**ADC Planning Consultation
Response from the Conservation Officer**

Application Number	Y/53/15/HH
Address	Church Farm House Church Lane Yapton BN18 0EP
Description	Replacement of existing mansard garage roof with new pitched roof & conversion of former garage into ancillary residential accommodation to main dwelling.
Case Officer	Mr. R Leal

View on North Elevation

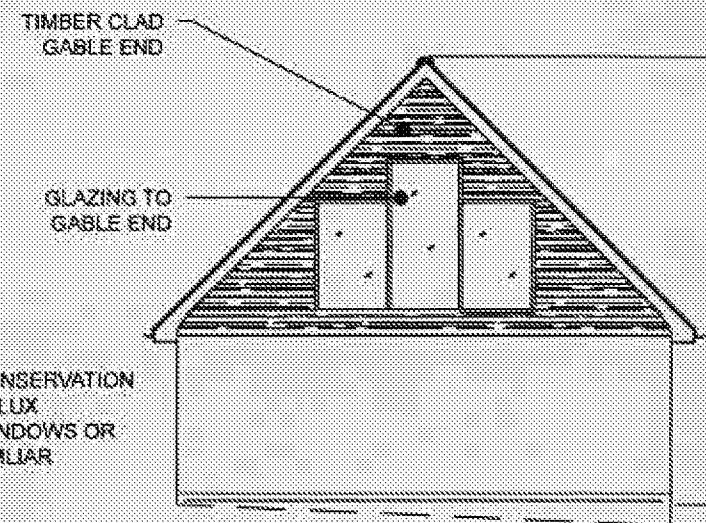
It is considered that the use of a pitched roof is acceptable. The fenestration on the north elevation is substantial in nature and details of the final design will need to be viewed before construction, along with details of the wooden boarding.

Details of the windows and doors
Details of the roof lights
Tile sample
